Carriage Meadows Townhomes Traffic Impact Analysis (LSC #184720) October 24, 2019

Summary of Comments on Microsoft Word - Carriage Meadows Townhomes TIA Oct 2019

[PUDSP-19-005](#)

Figure 2
Site Plan

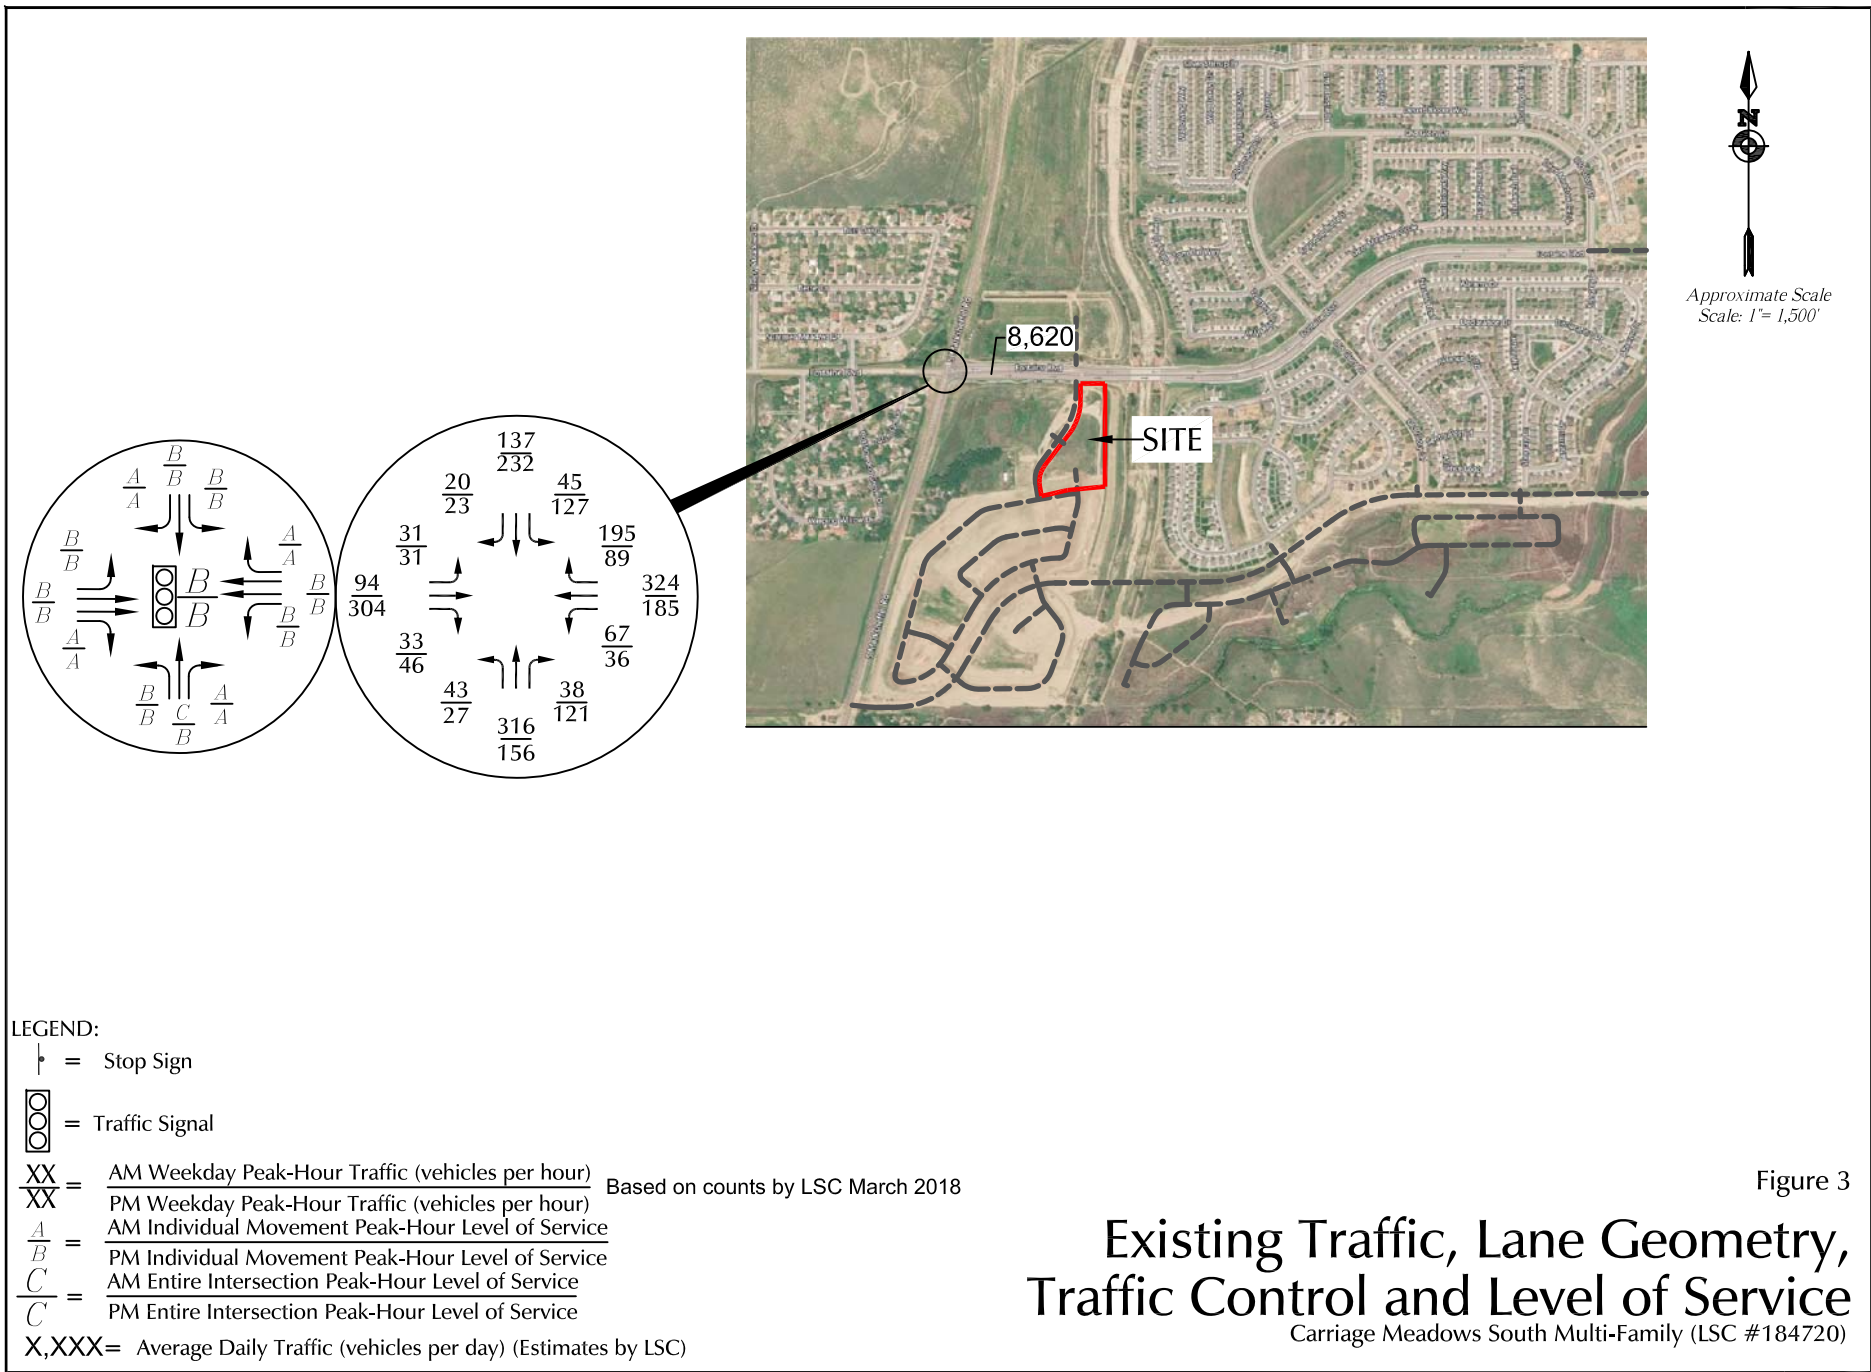
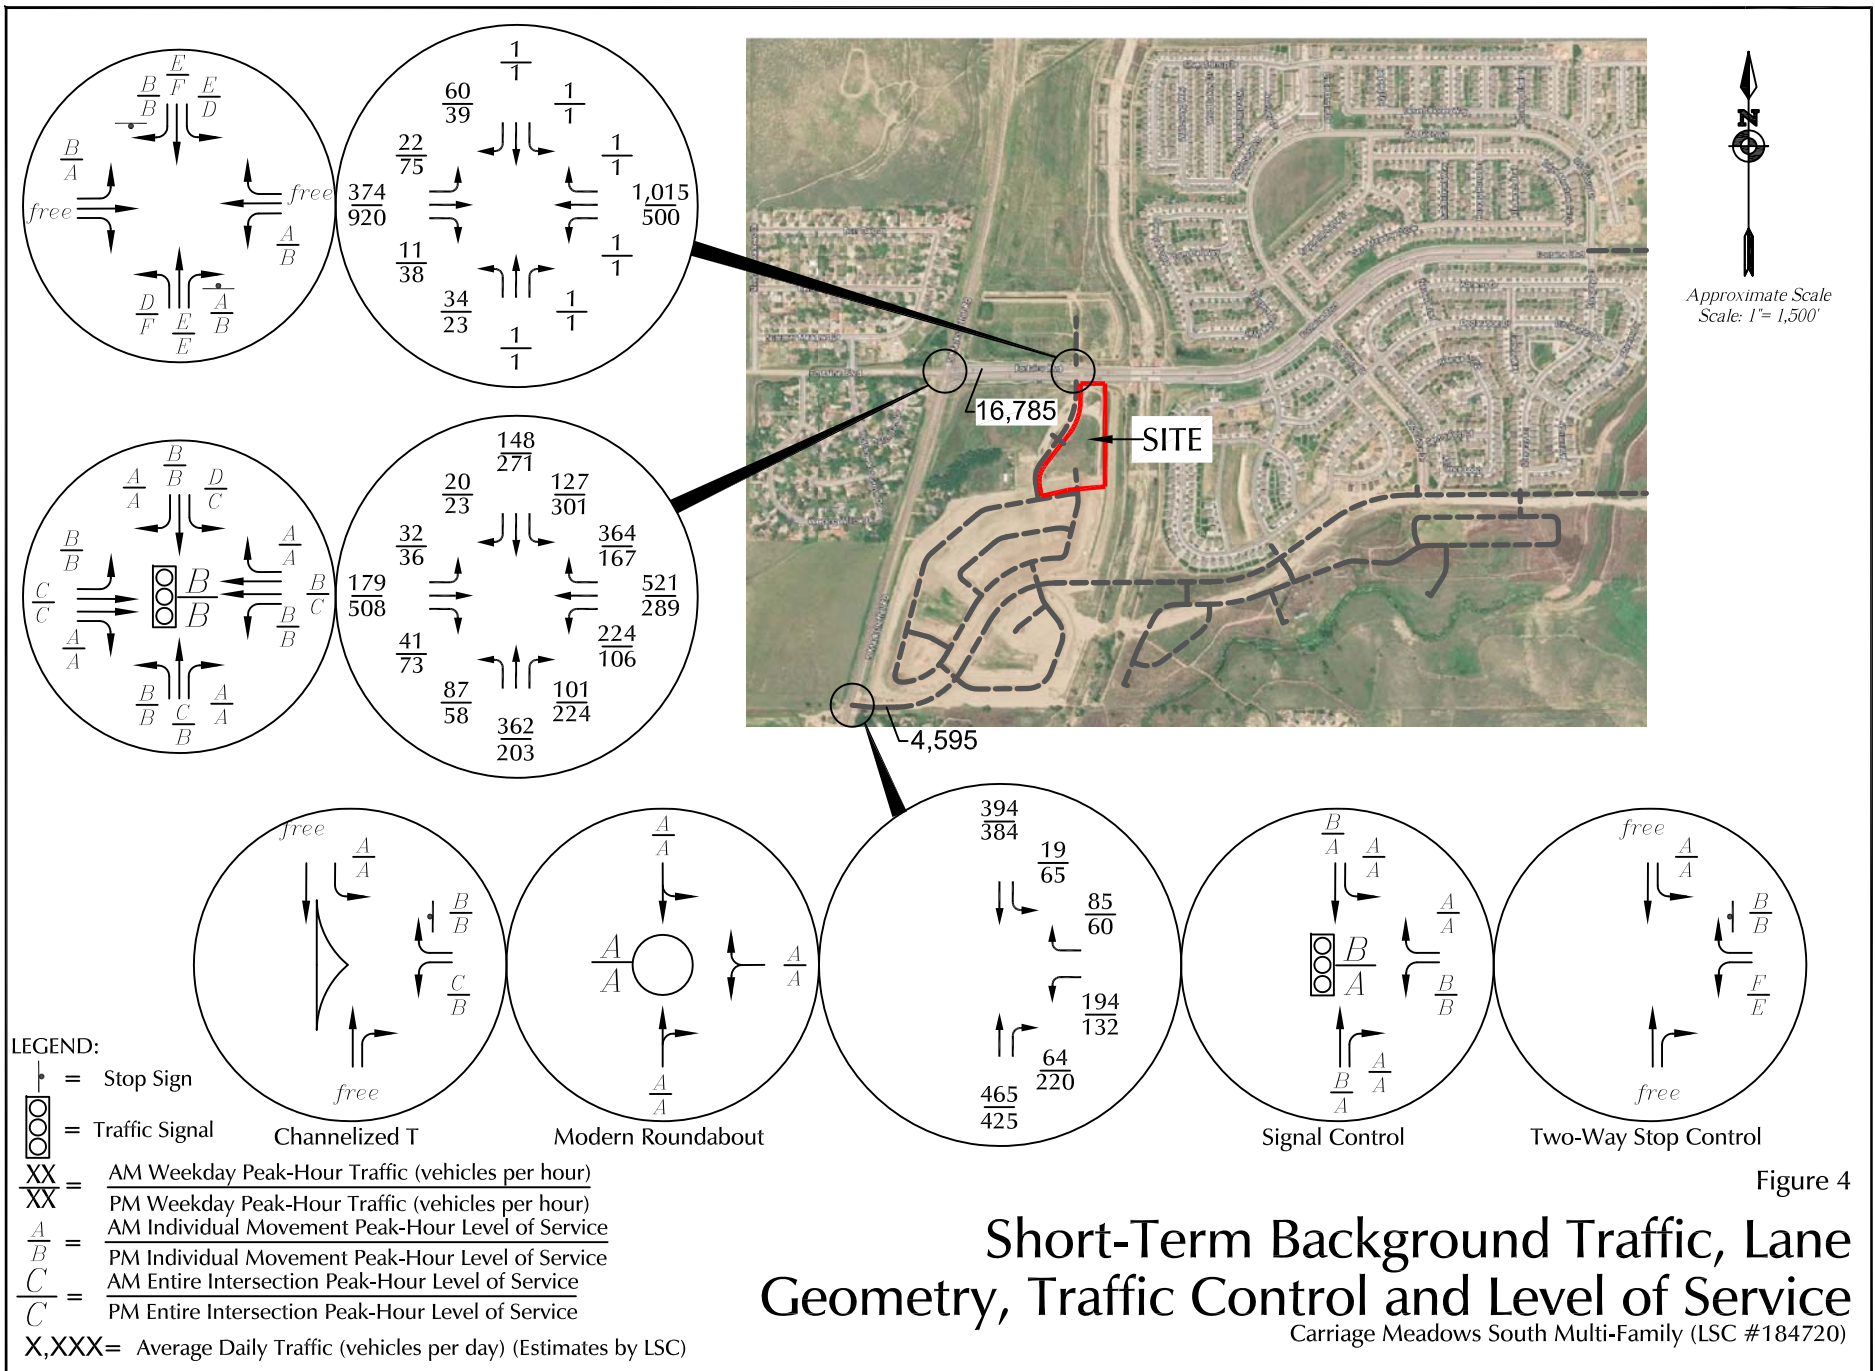
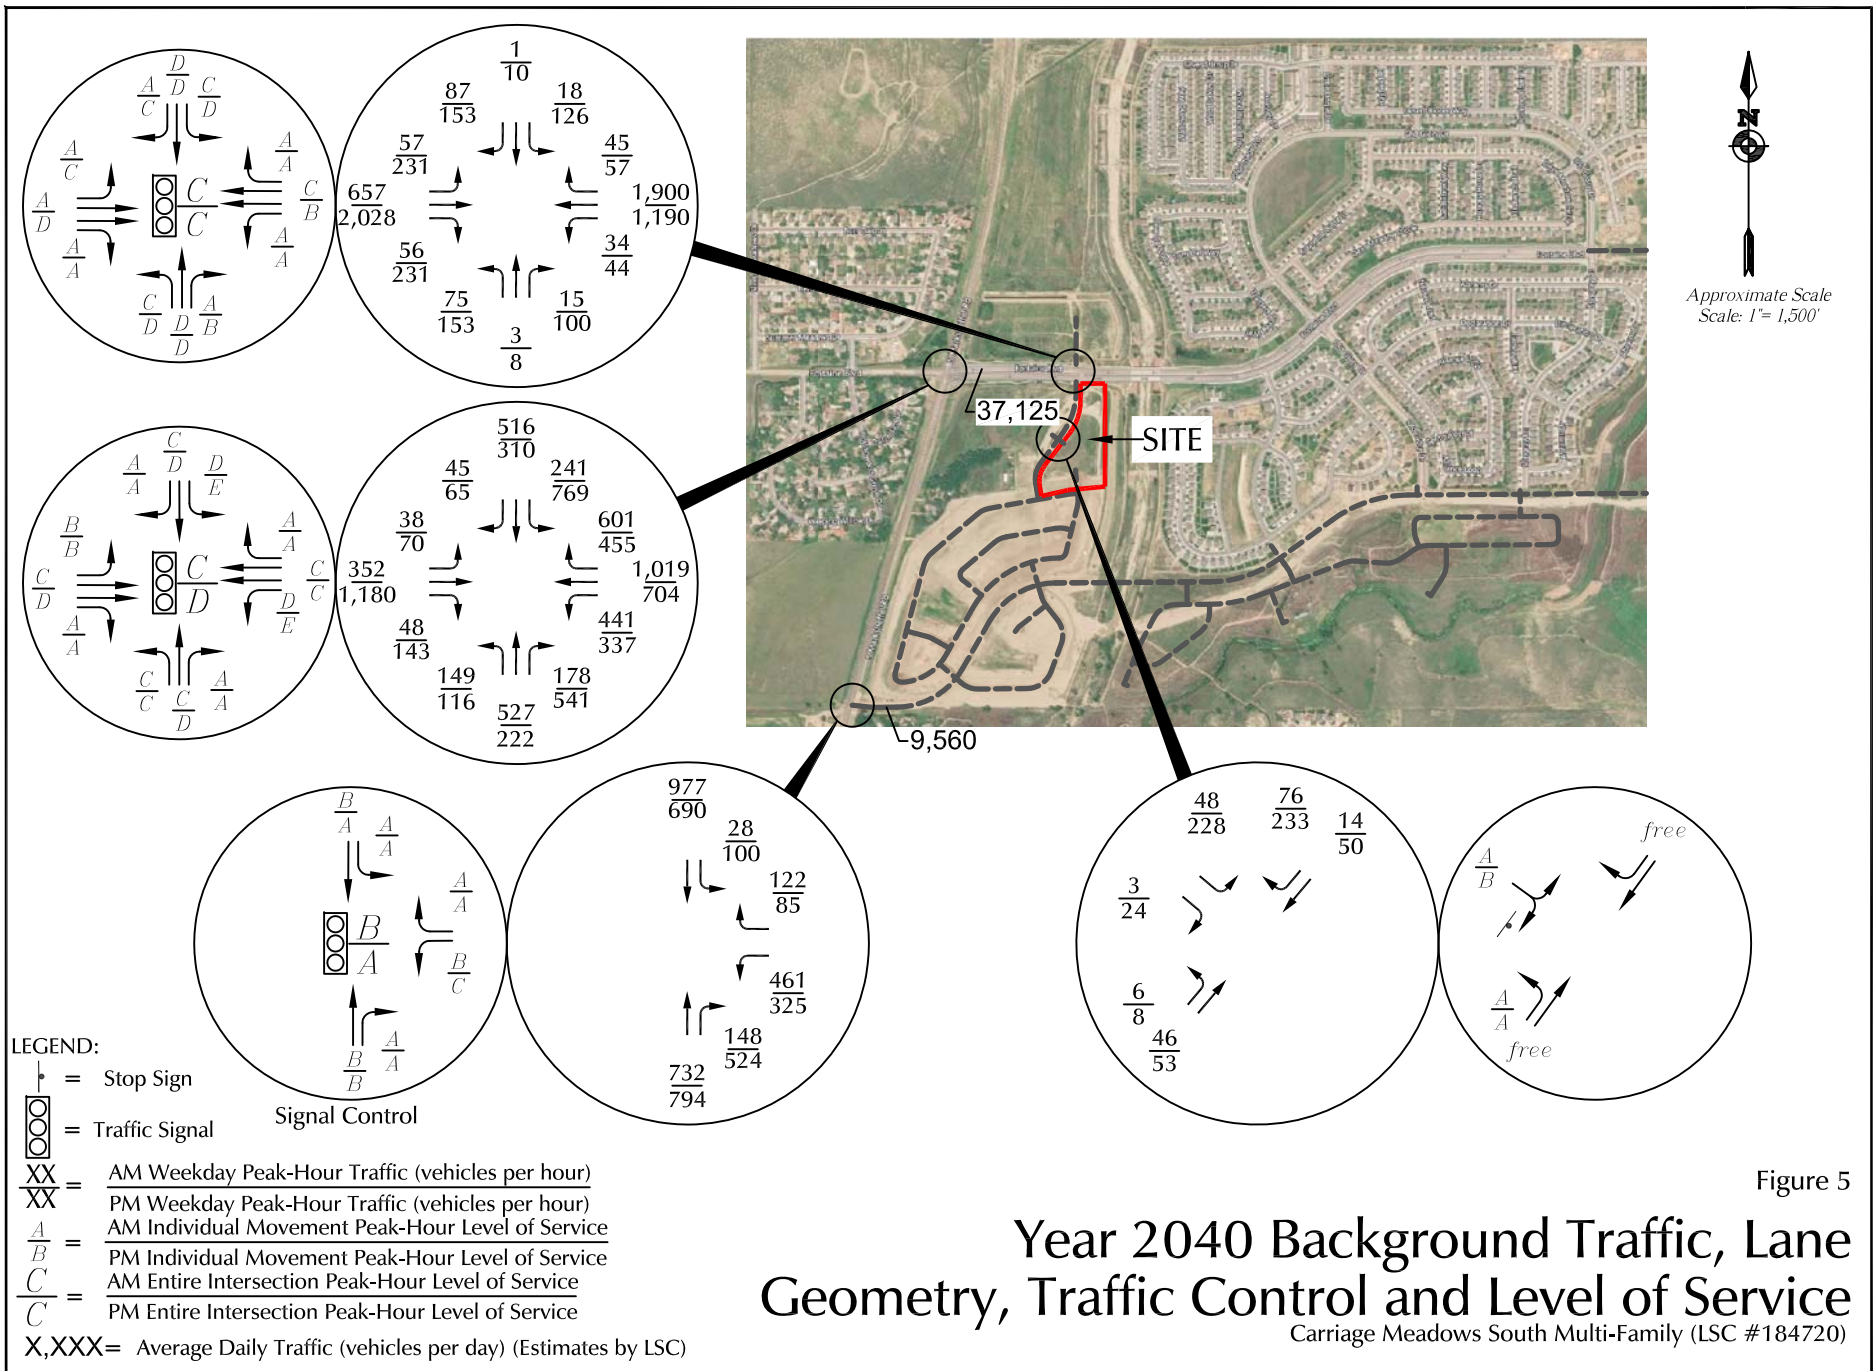
[Update to maximize NB left turn lane](#)

Author: jchodsdon Subject: Sticky Note Date: 1/11/2020 12:53:24 PM
LSC Response: This has been addressed in the updated TIS report. Please refer to Figure 13 and the report narrative.
